CITY OF ALBUQUERQUE

March 15, 2017

**RE: Eagle Ranch MVD – Retail Drainage Report
Eagle Ranch Rd
Engineer's Stamp Date: 2/20/17
Hydrology File: B13D002C**

MAPS

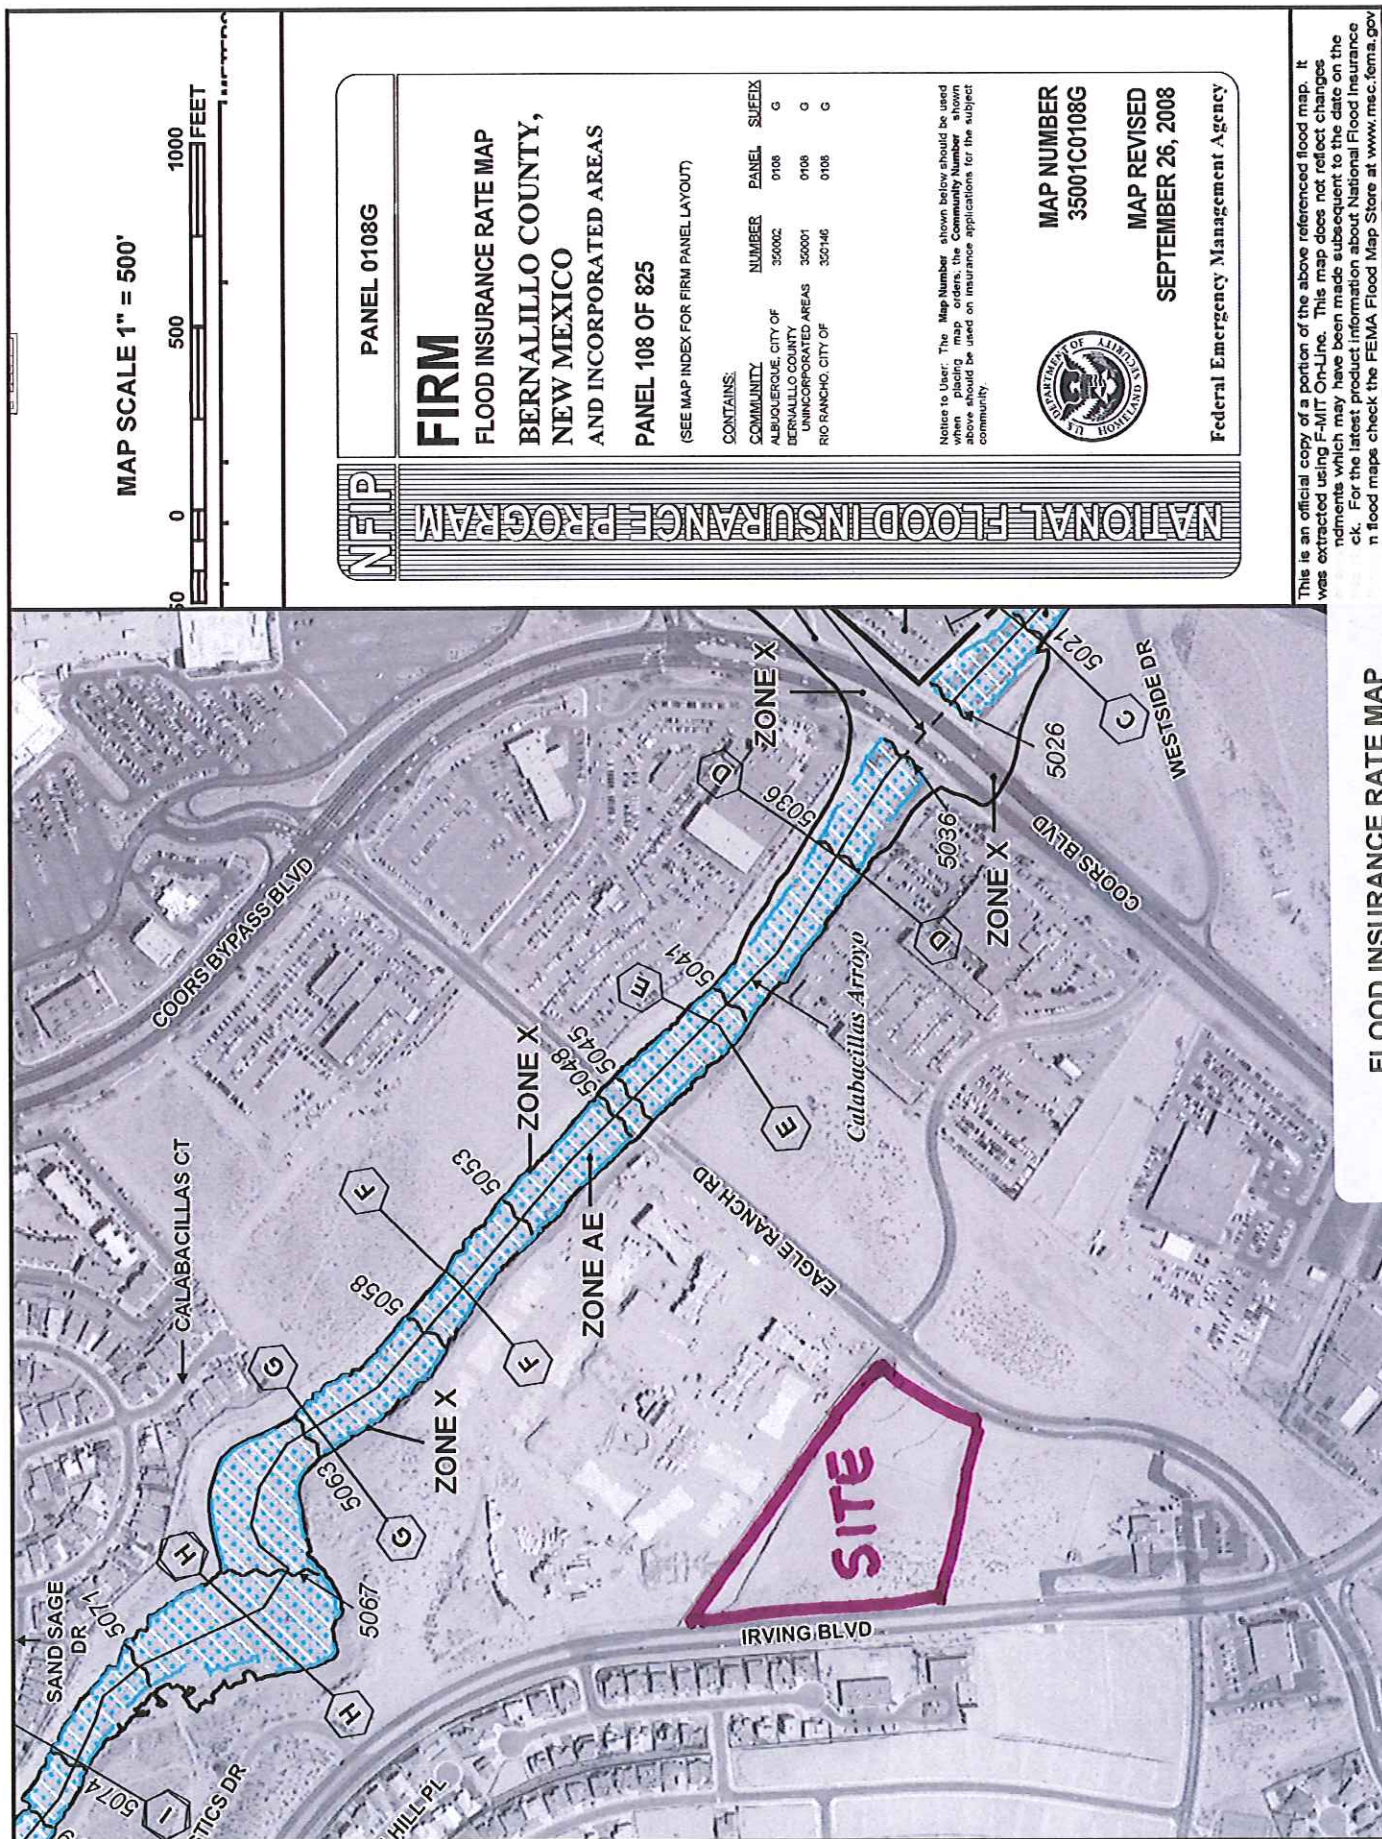
- b. The master plan for this area is for SAD 224; the downstream system was built with City Project No. 4392.90.
3. On figure 1 and 2 of the report body, show/label the site location.

SHEET NUMBER
C-1.0

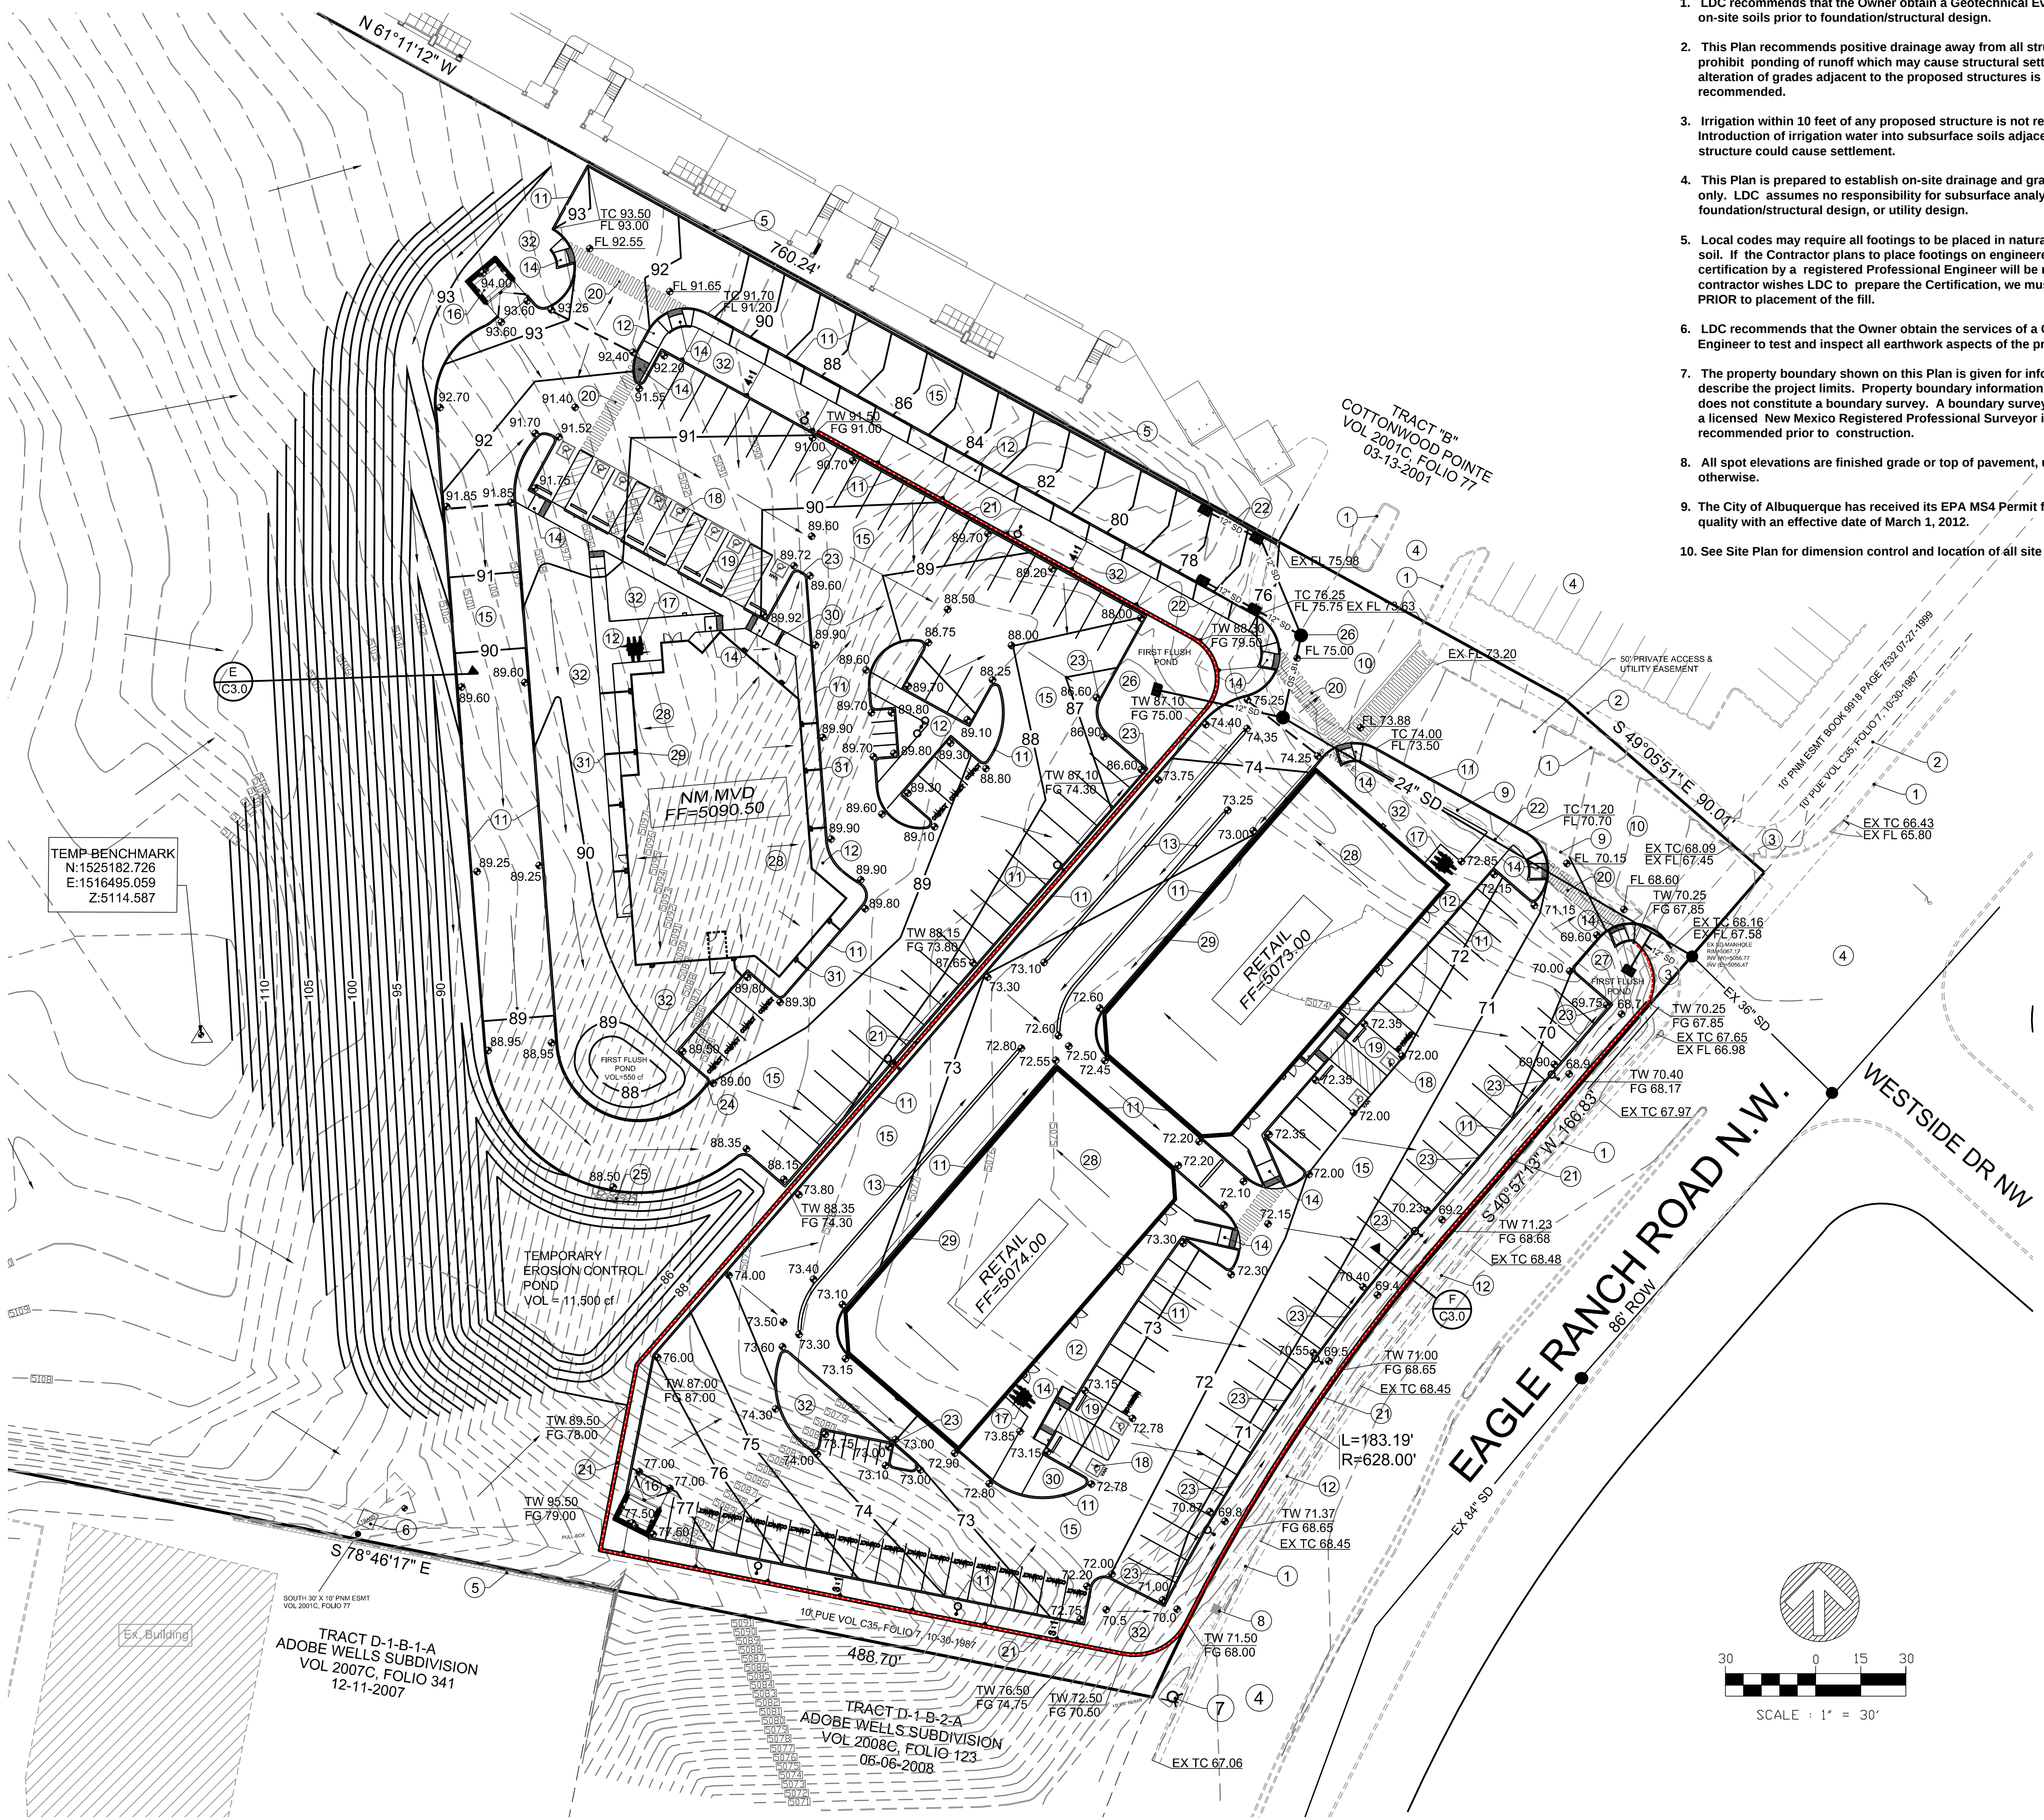
1. It is unclear how storm water quality requirements are met.
 - a. The proposal to route flows through 3" deep landscape areas does not acceptably pond onsite and allow to infiltrate, as the landscaped areas are not flat and will not uniformly pond 3" of water.

- b. There are several landscaped areas and parking islands that appear to be flat enough and large enough to depress and capture additional volume. These areas should be modified with curbcuts to allow inflow and calculate their volumes for additional storage.

2. Downstream Capacity.
 - a. No master plan for this area is discussed; the capacity of the 36" storm drain stub out and downstream needs to be investigated to show the system has capacity for the increased runoff.

5. Retaining Walls. The retaining walls as presented are acceptable; however they may become a clear sight hazard if they are to be topped with garden walls. The intersection with Eagle Ranch is the biggest area of concern. Additionally, several retaining walls are 10-15ft high; it may be more economic terrace these down.
